DOC 19/76562-11
SSD 8660

OEH Review of Environmental Impact Statement: Kariong Sand and Soil Supplies Facility (SSD 8660), Somersby – Central Coast LGA

I refer to your email dated 31 January 2019, seeking comments on the Environmental Impact Statement (EIS) for the proposed Kariong Sand and Soil Supplies project (SSD 8660), located at 90 Gindurra Road, Somersby (Lot 4 in DP 227279), in the Central Coast Local Government Area.

CONCEPT STORMWATER MANAGEMENT PLAN

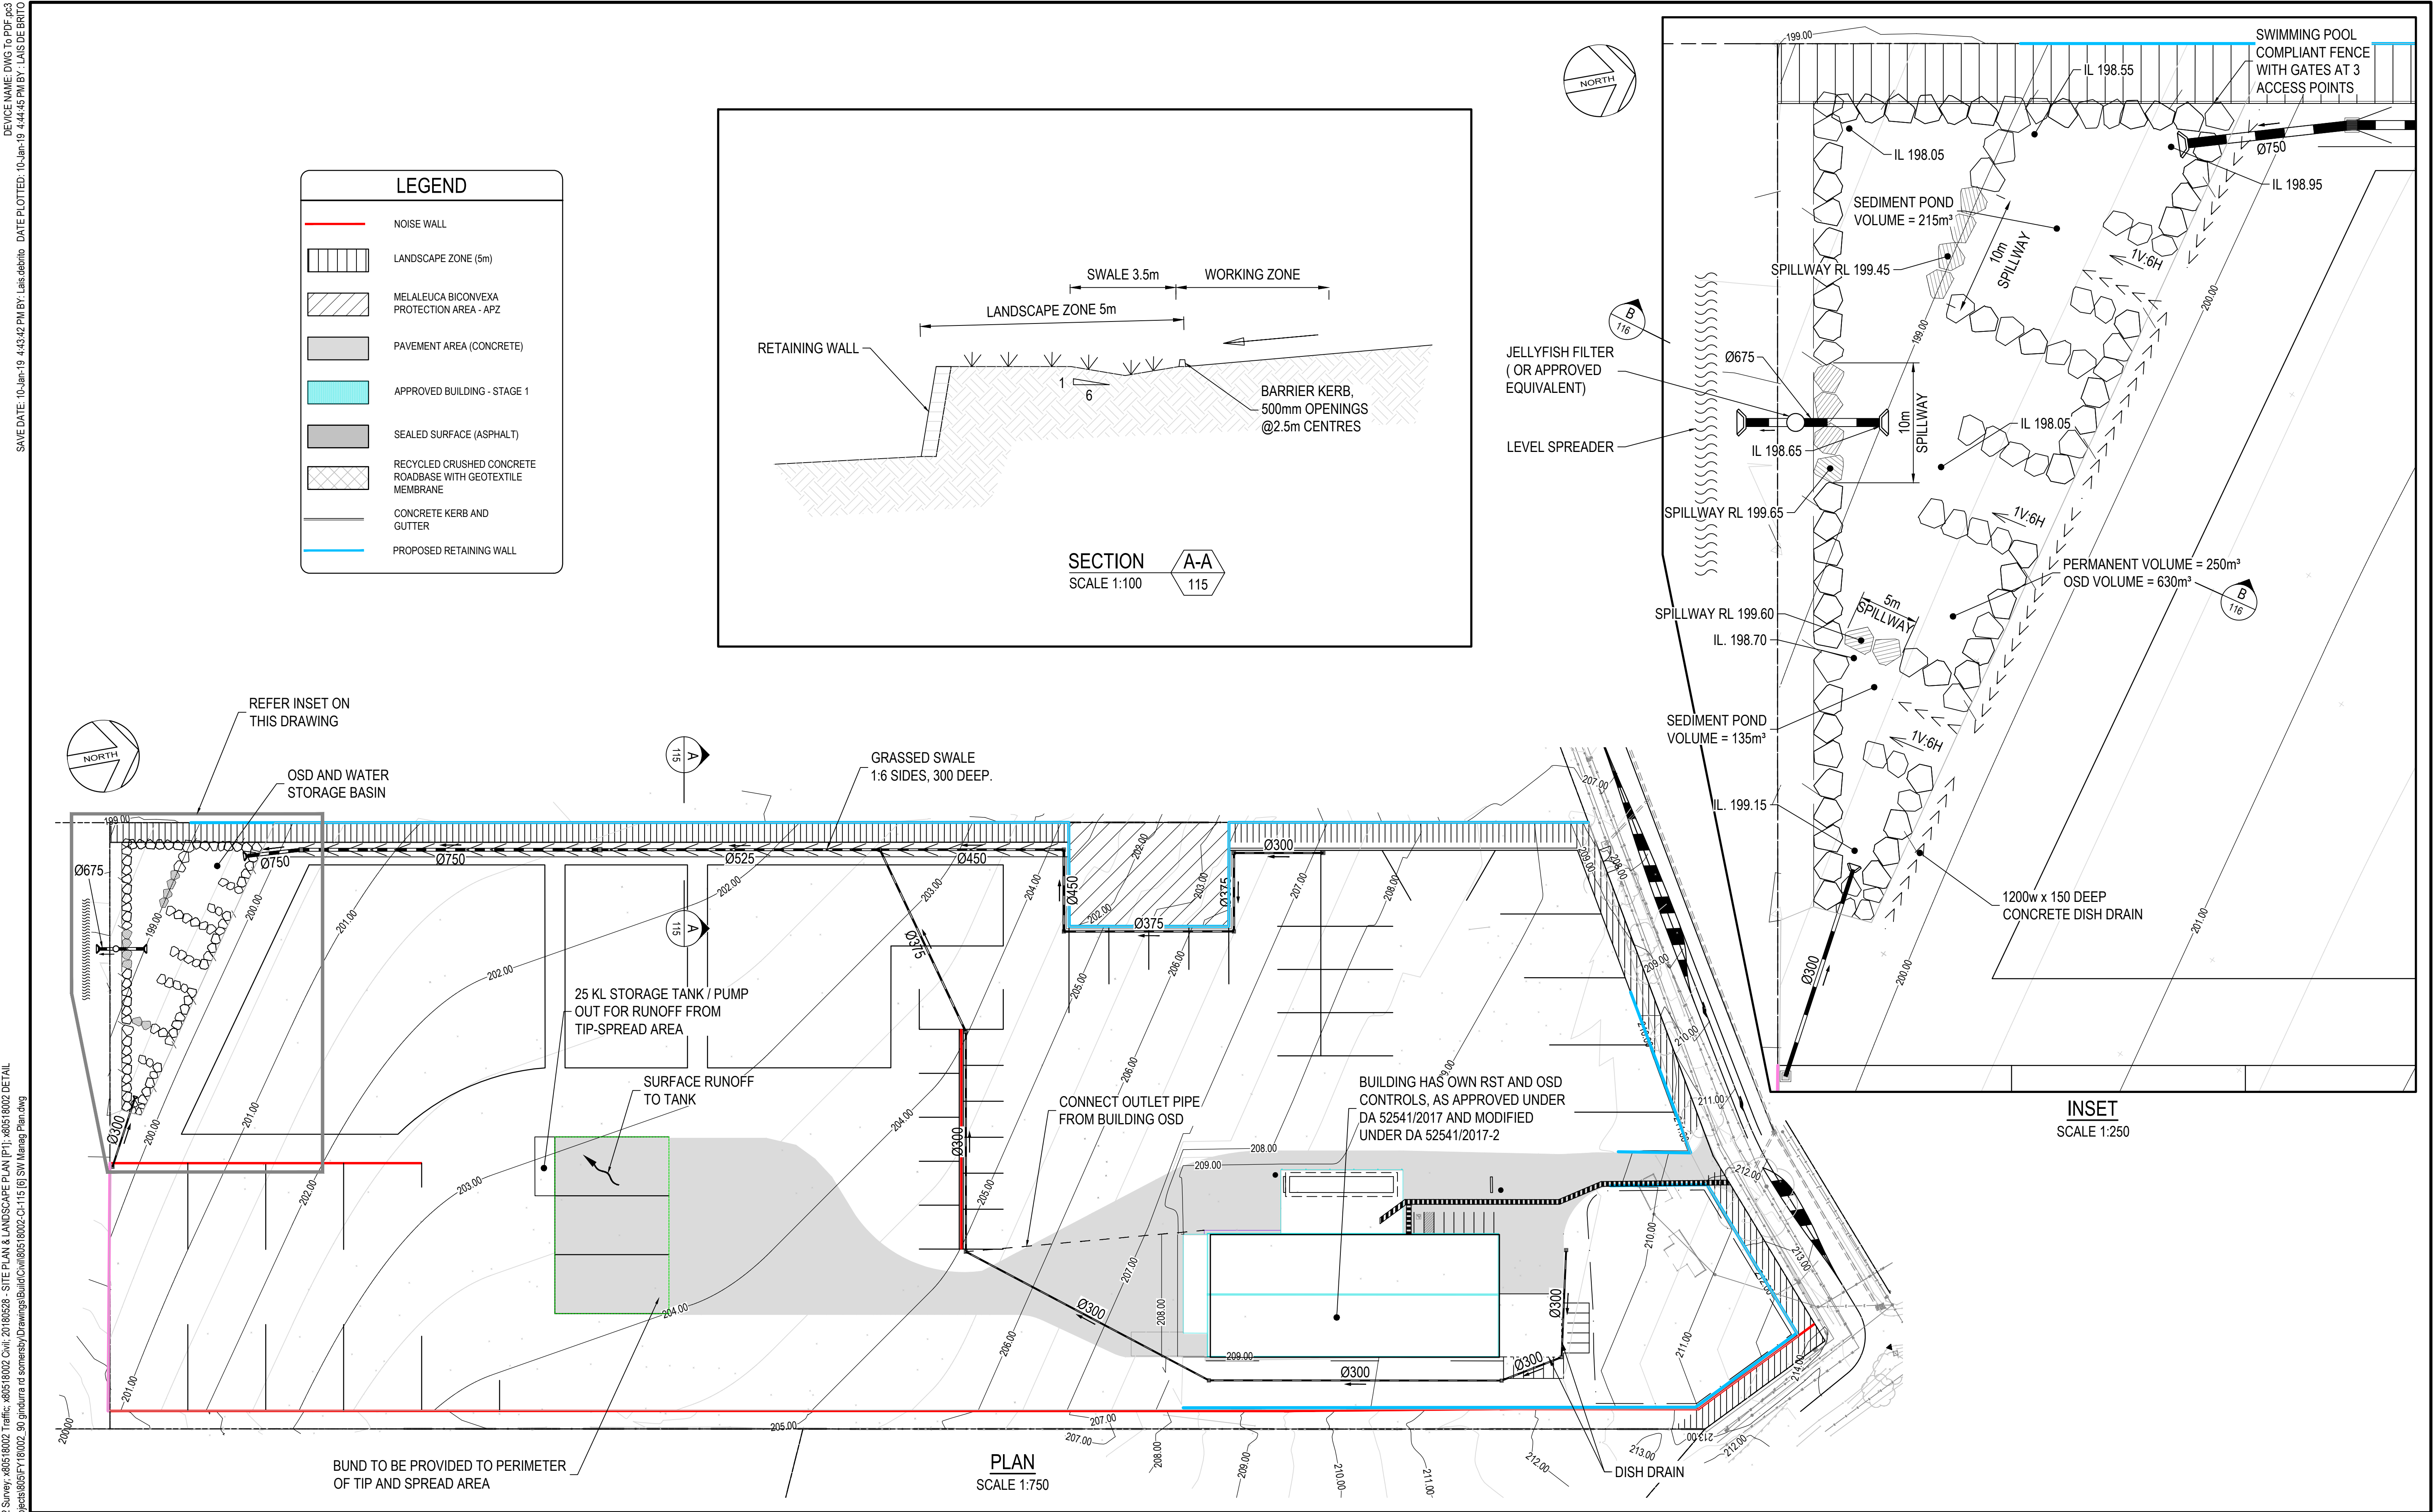
Concept civil engineering plans by Cardno (NSW/ACT) Pty Ltd (Cardno NSW) indicate the following changes in the area around this vegetation: site filling/regrading, provision of bentonite (impervious) working areas, and provision of diversion drains to divert site stormwater around this vegetation. OEH does not consider that a 10-metre-buffer will be suitable to offset these impacts.

All of the above changes will reduce runoff received by the vegetation to less than that provided by current runoff. *Melaleuca biconvexa* is known to inhabit damp areas or areas adjacent to watercourses (NSW Scientific Committee 1998) and may be adversely impacted by changes to hydrology from the proposal. These potential impacts have not been assessed by the EIS.

OEH recommends that the impact of changes to hydrology resulting from the proposal be assessed for *Melaleuca biconvexa* and appropriate mitigation measures be provided if required, including the retirement of species credits if long-term survival cannot be guaranteed. If the retirement of species credits is needed, the BAM Credit Calculator will need to be rerun.

The impact of changes to hydrology resulting from the proposal should be assessed for the *Melaleuca biconvexa* community adjacent to the site and appropriate mitigation measures should be provided where required.
